Application No: AB/50/21/L
Site Address: Old Bank House 1 High Street Arundel BN18 9AD
Description of works: Listed building consent for the replacement of all windows with new timber double glazed sliding box sash windows and the proposed rendering of the South Elevation (front) and the West Elevation (side) with render painted white.

Thank you for your internet representation made on 16th May 2021 which has been recorded as an objection with the comments as follows:

Replace all existing windows with new timber double glazed sliding sash windows painted white

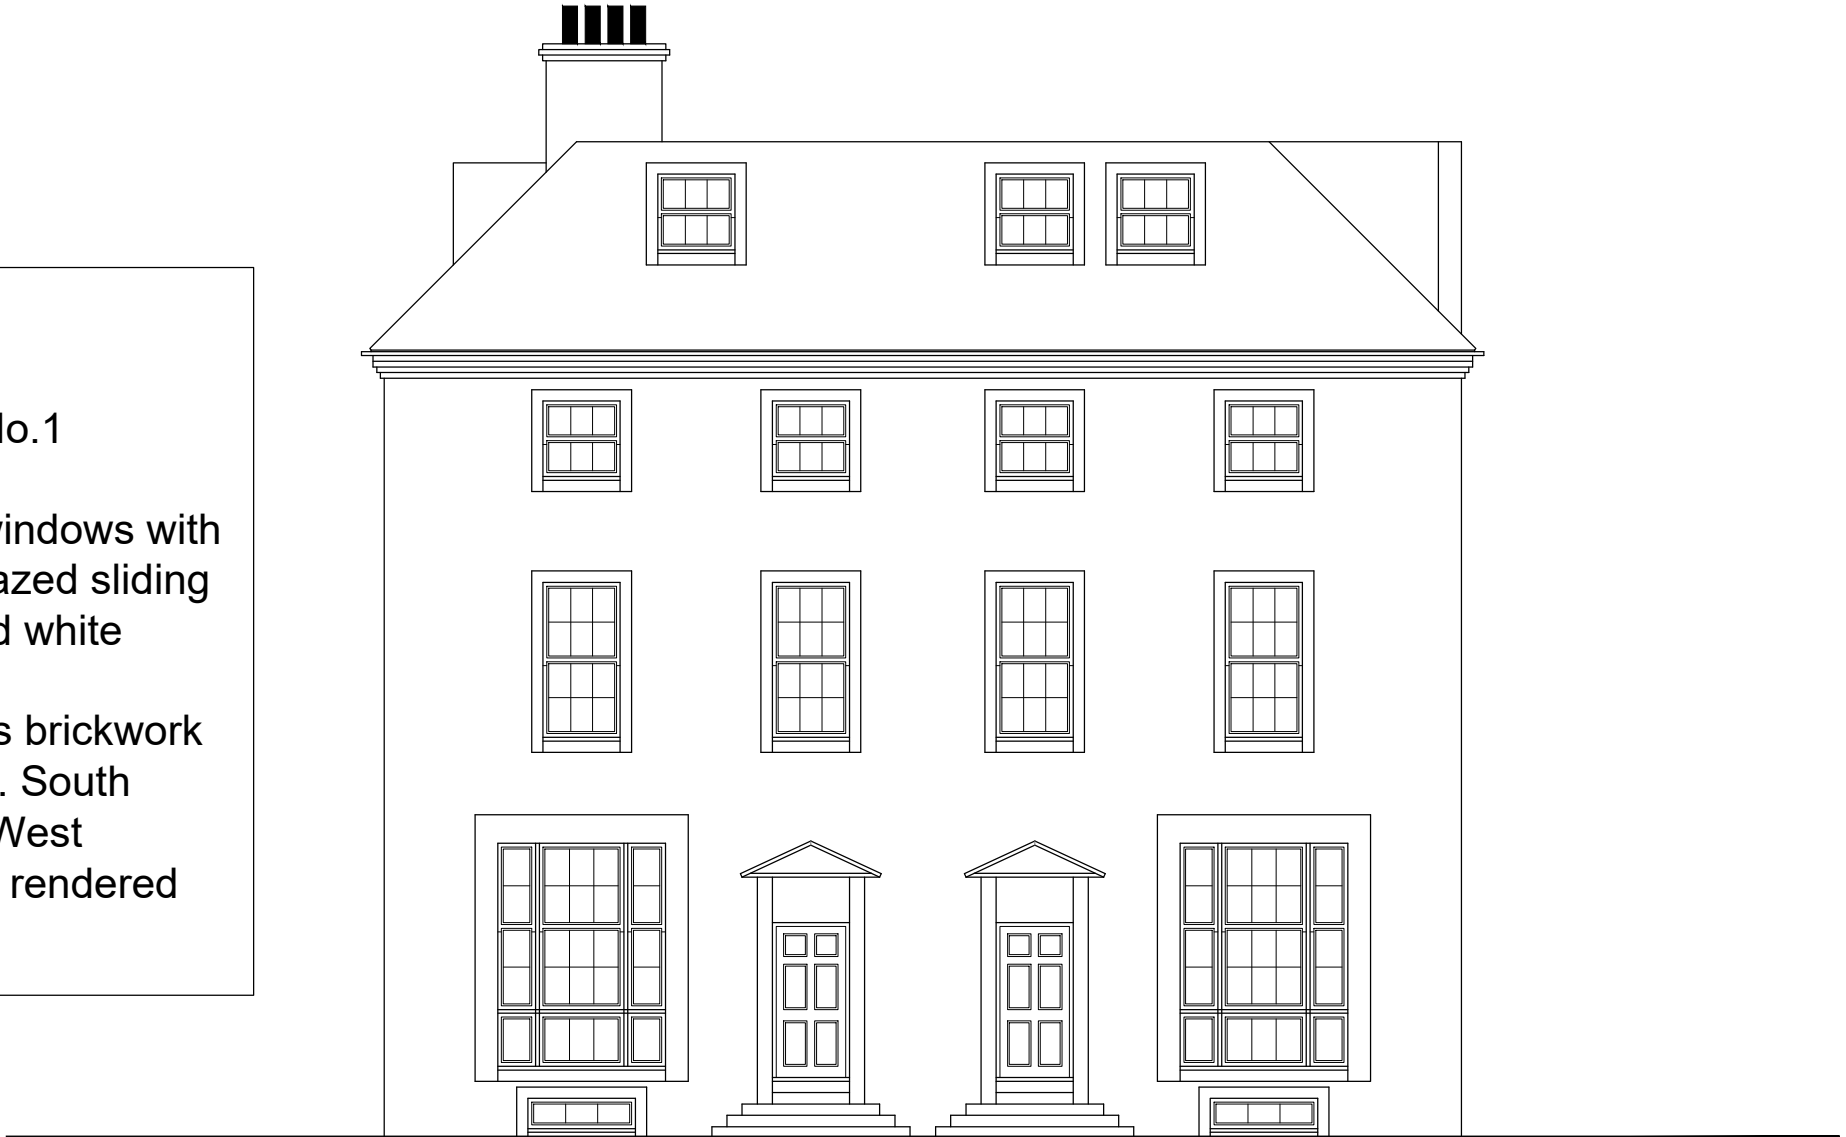
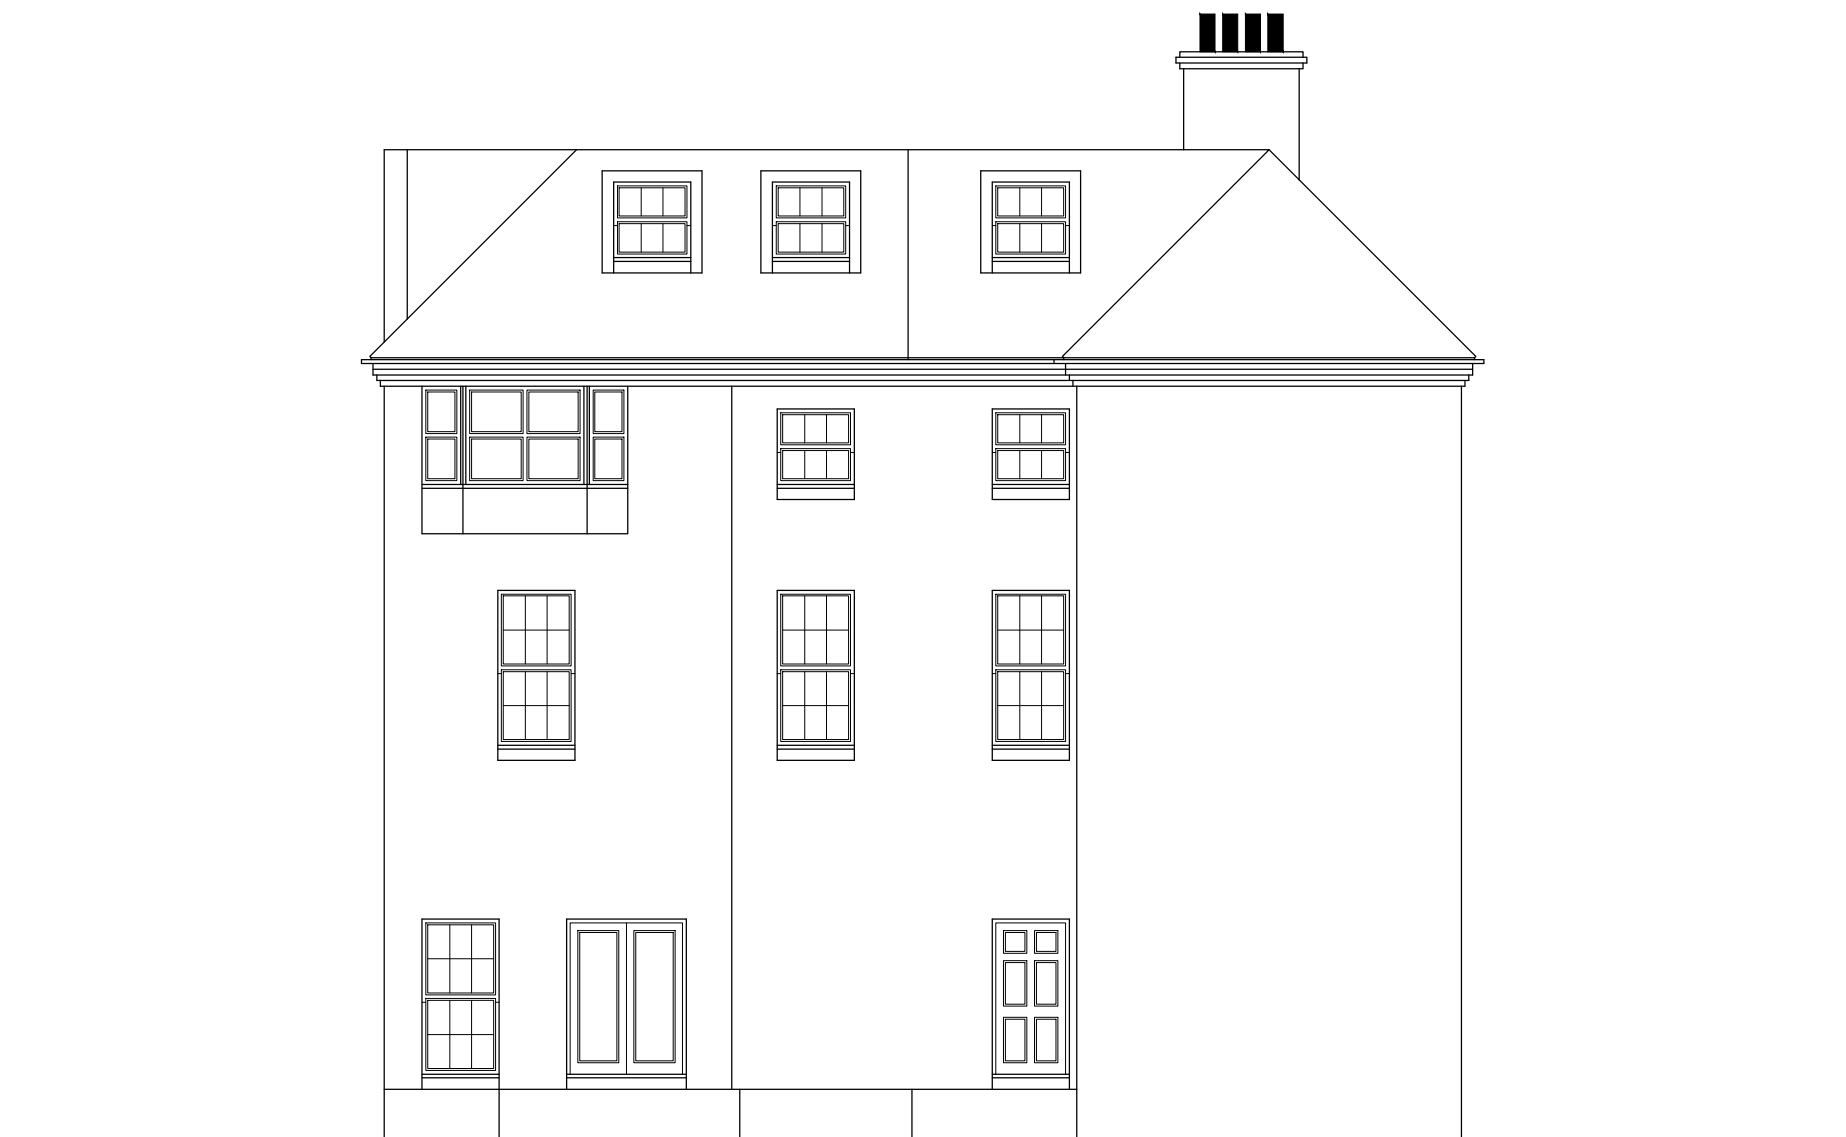
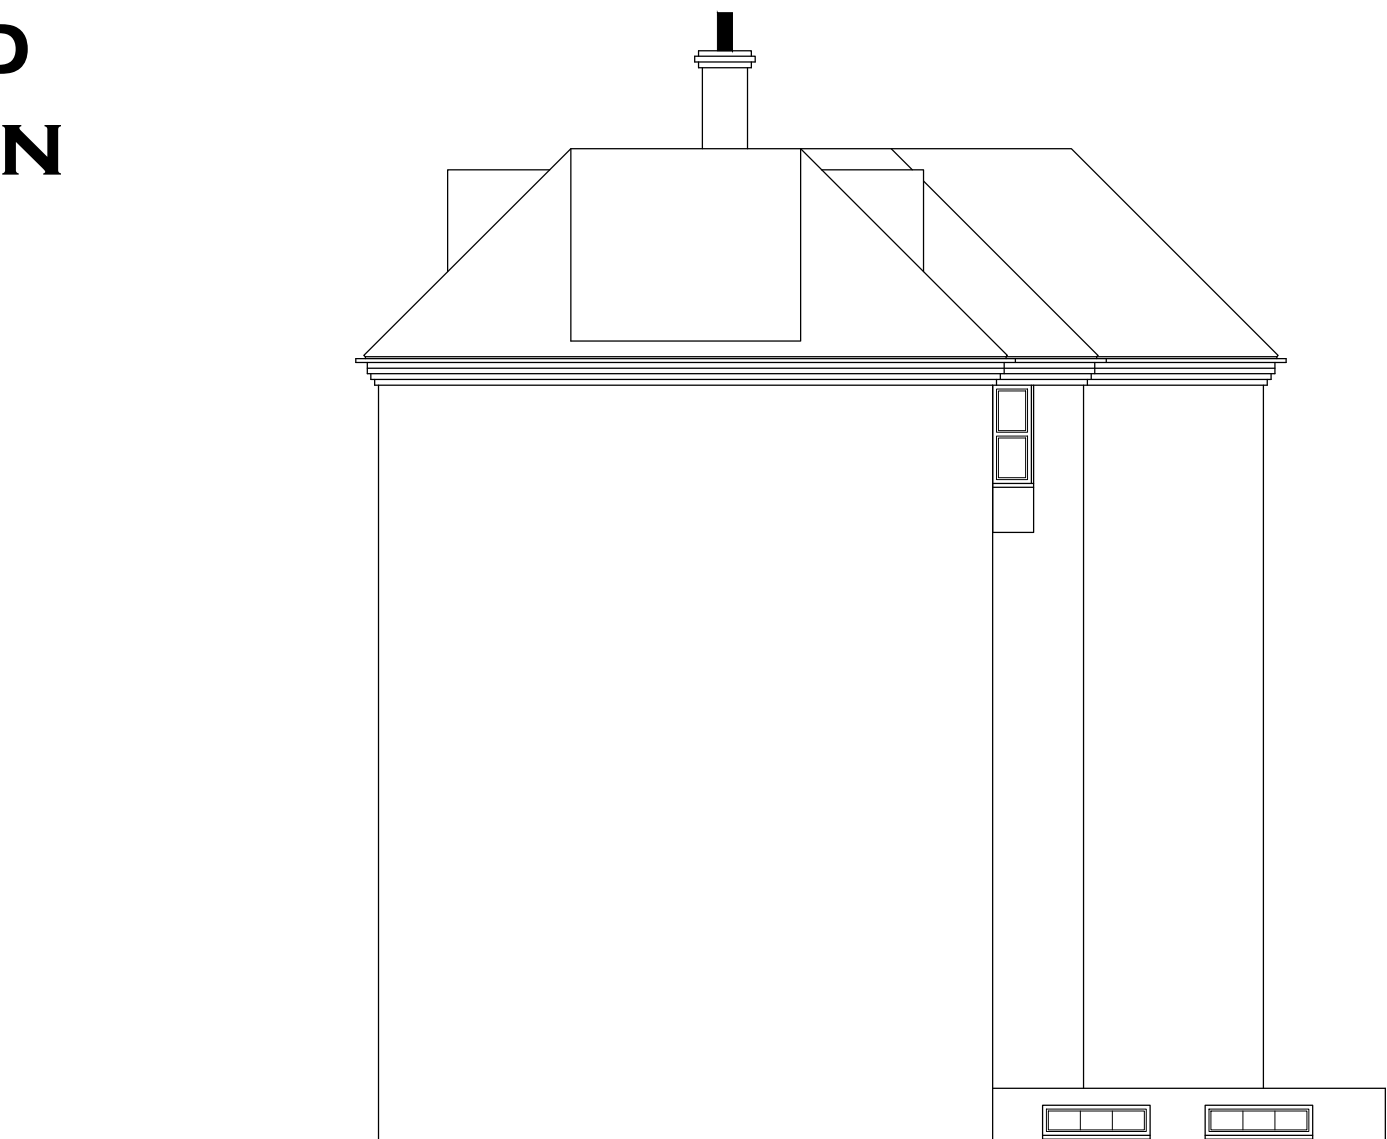
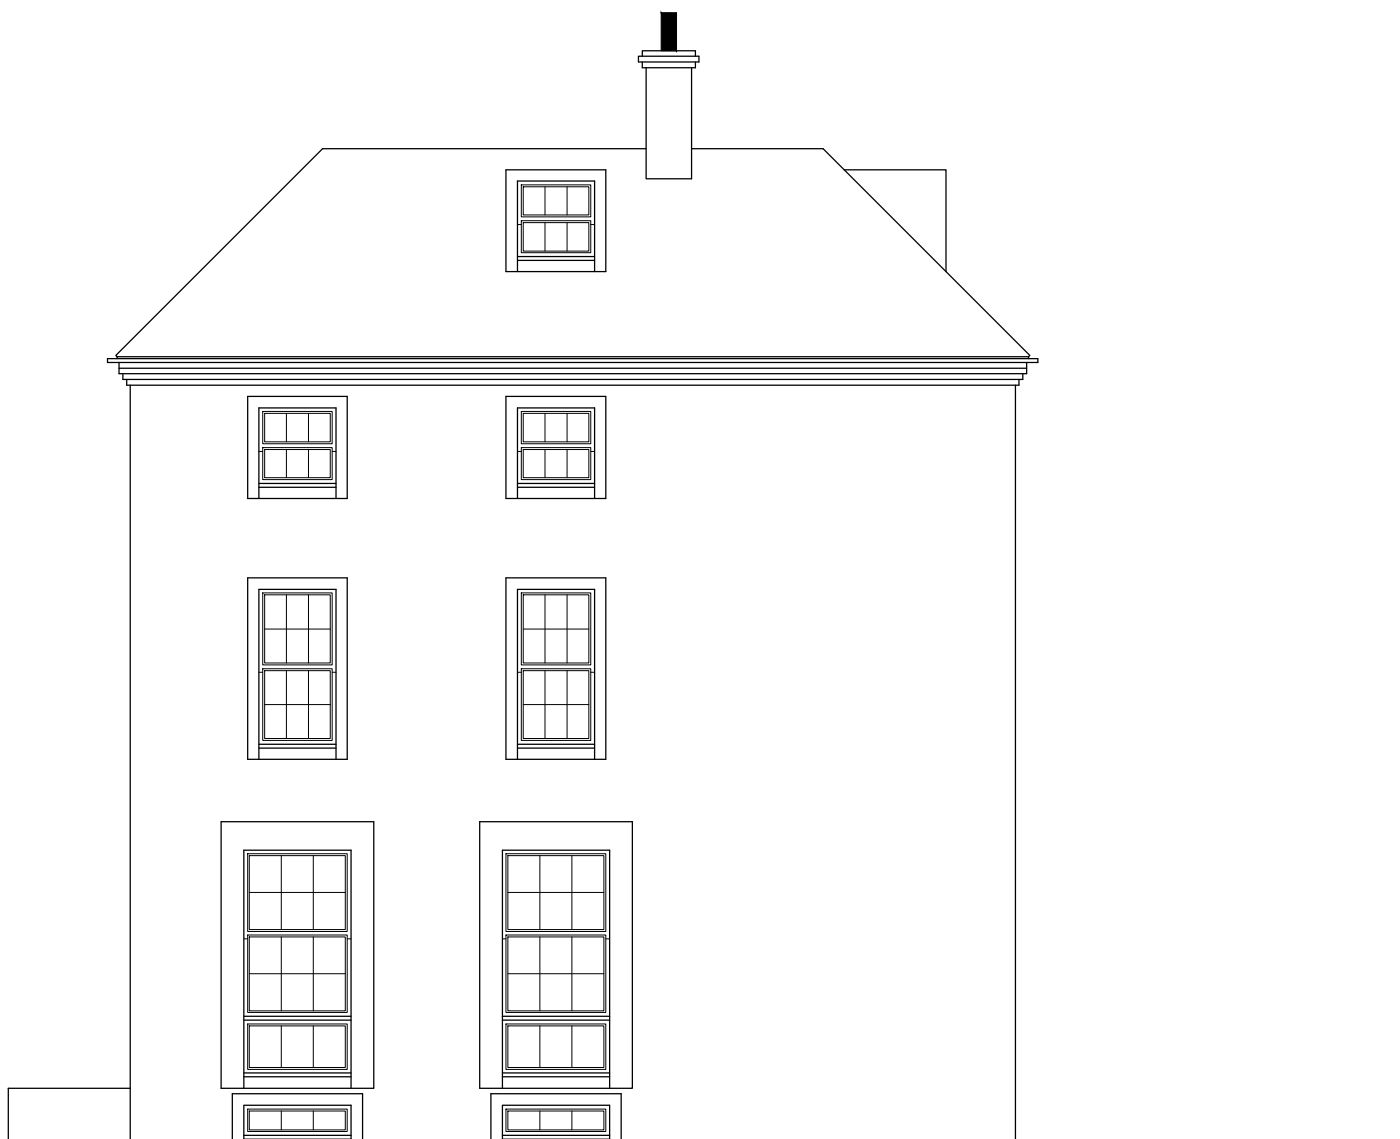
The replacement of this important fenestration with timber double glazed windows with their thicker glazing, dead flat appearance to the glass, and thermal spacers and edging will materially detract from the historical and architectural significance of this listed building. It is difficult to ascertain from the submitted plans how glazing bars, if any, will be treated. It is either intended to use false 'stick on' bars or to use properly formed bars but these would need to be thicker than the originals in order to take the extra weight of the double glazing (this would also likely be the case even with slimline double glazing units). Either detail is simply not appropriate since the existing traditionally constructed slender glazing bars are so important to the character and appearance of the historic building.

The wholesale replacement of the existing windows represents a substantial loss of historic fabric. The nationally accepted approach is that repair should be explored first before the decision to replace and there is ample advice given by Historic England in its various publications. This issue is not addressed in the Heritage Statement. Considerable advice is also given by Historic England on the various methods of thermally insulating historic buildings without recourse to double glazing.

Without detailed proposed full elevational plans of the various window sizes contained in the building it is difficult from the plans submitted to ascertain final appearances.

In any event, the works of replacement with double glazed units are totally unacceptable and consent should be refused.

The proposed replacement windows works will undoubtedly adversely affect the character and appearance of the building and also that of the conservation area. If listed building consent is granted there will be a dangerous precedent for other similar works not only within the Arundel Conservation Area but in historic buildings across the District giving rise to a major adverse impact on its historic environment. The works fail to comply with the relevant paragraphs of the NPPF and policies contained in the ADLP relating to the protection of designated heritage assets. cont. second submission
